Response to Planning application from Hertfordshire County Council (T and CP GDP Order 2015)

District ref: 6/2020/3451/MAJ
HCC ref: WH/5158/2021
HCC received: 11 January 2021
Area manager: Matthew Armstrong
Case officer: Samuel Tearle

WELLS FARM NORTHAW ROAD EAST CUFFLEY POTTERS BAR EN6 4RD

Demolition of existing buildings and erection of 14 dwellings

TITLE:
**Proposed Site Access
and Visibility Splay
(2.4m x 160m)**

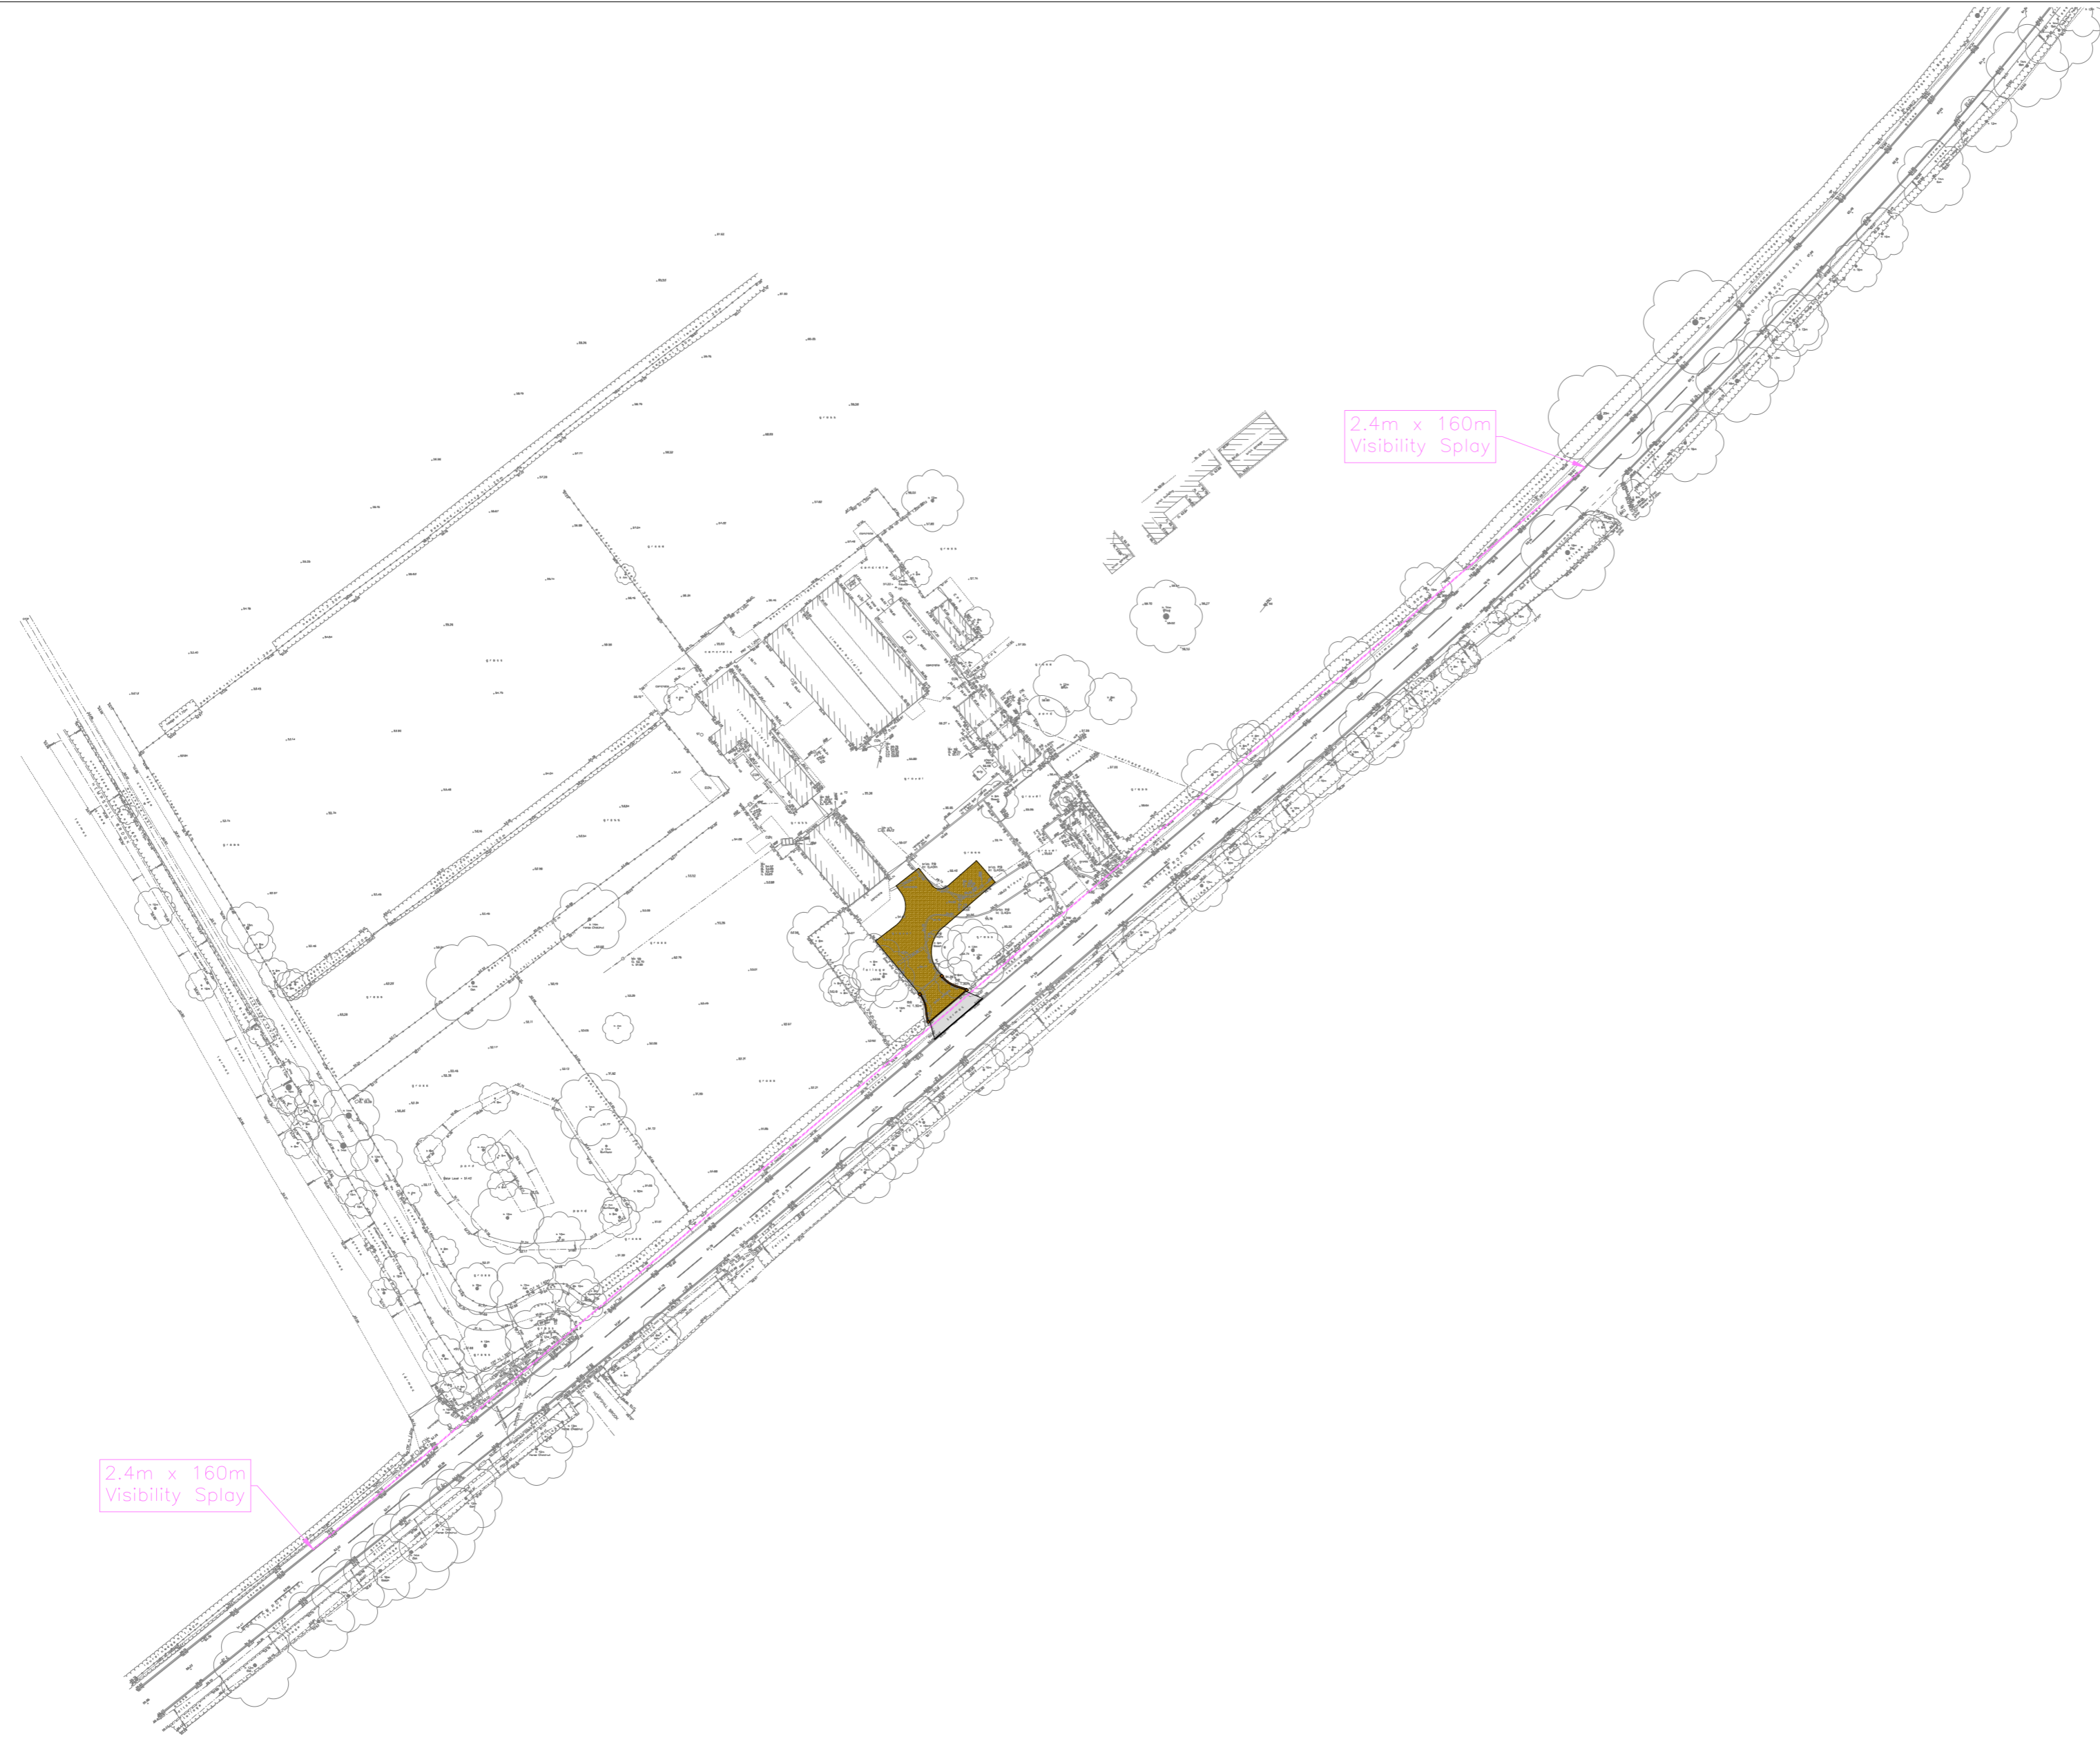
Prior to the first occupation / use of the development hereby permitted a visibility splay shall be provided in full accordance with the details indicated on the approved plan number (1911-066.PL03 Rev C). The splay shall thereafter be maintained at all times free from any obstruction between 600mm and 2m above the level of the adjacent highway carriageway.

Improvements to the condition / material of the footway at the footway crossover have been shown on 1911-066.PL03 Rev C and new dropped kerbs will be required. It is likely this will need to be provided by a S278 agreement.

The results contained in the Appendix of the Technical Note have shown that the 85th percentile speeds do not differ between northbound and southbound directions, and that the 85th percentile speed at the site access for a 7-day average was 47.2mph. Based on the interpolated method of SSDs contained in Table 2.10 of CD109, this would require a (Y) visibility splay of 138m.

The applicant has submitted visibility splay drawing (1911-066.PL03 Rev C) in the appendix of the Technical Note. This drawing has demonstrated a visibility splay of 2.4m x 160m from the access. On the basis that the 85th percentile speed has been shown to be 47.2mph, the Highway Authority are satisfied with the 'one step below desirable minimum' SSD for a highway subject to national speed limit. It is requested by way of planning condition that the visibility splays are maintained.
